Your ref: CONPC/3/2020/0818  
Our ref: D3/2020/0818  
Date: 23 November 2020

**Planning Application No: 3/2020/0818**

**Proposal:** Proposed detached double garage

**Location:** 10 College Close, Longridge PR3 3AX

GARAGE FLOOR PLAN & ELEVATIONS

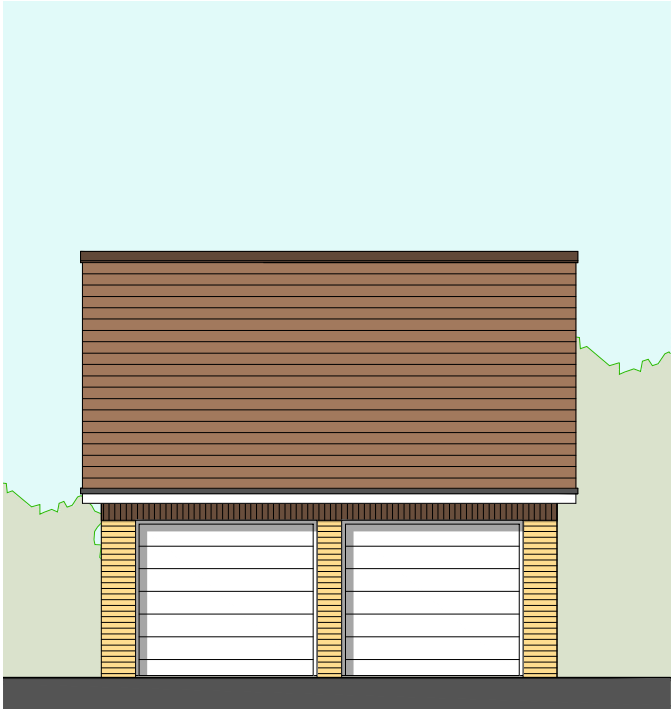
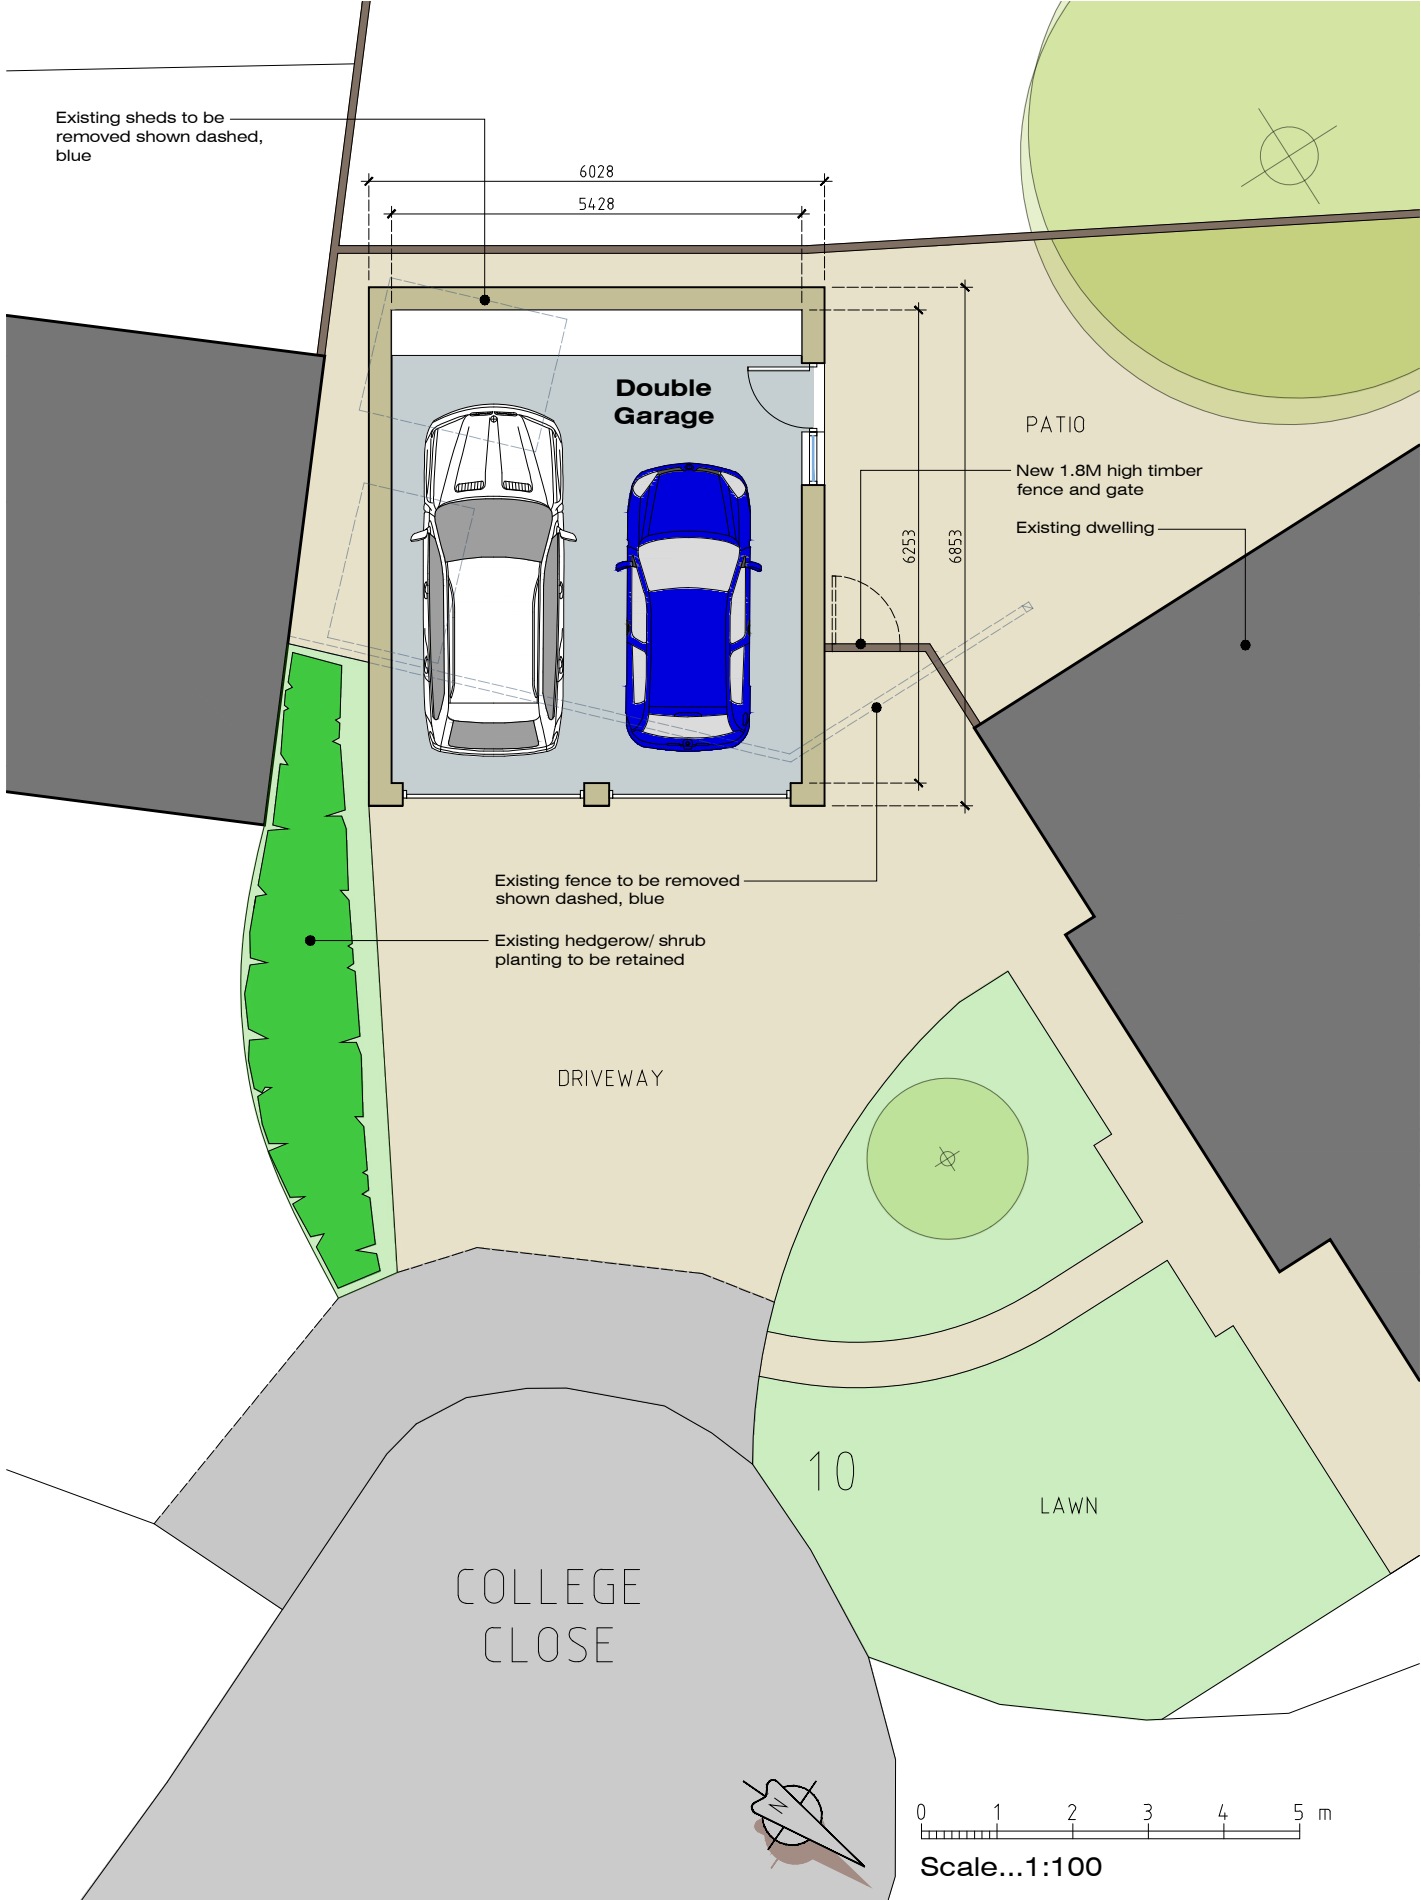
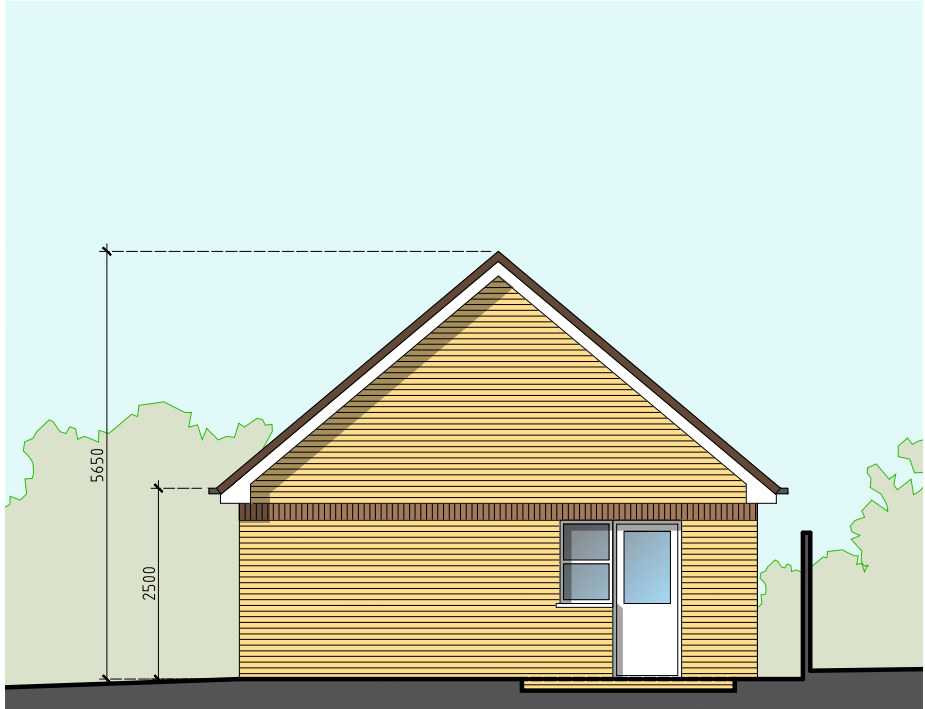
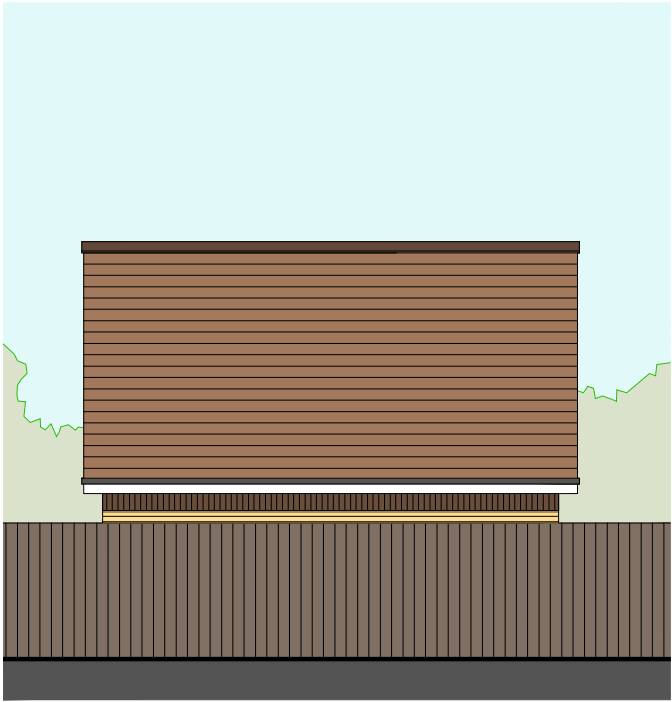
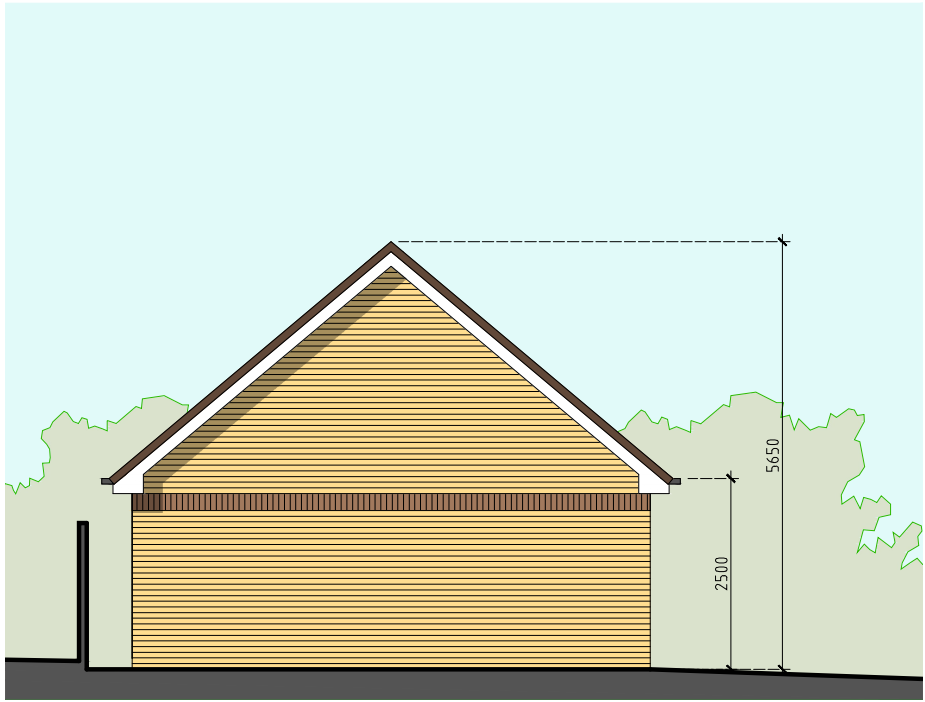
Double garages should have minimum internal dimensions of 6m x 6m to count as two parking spaces. As the proposed double garage has internal dimensions less than this it would only be considered as one space.
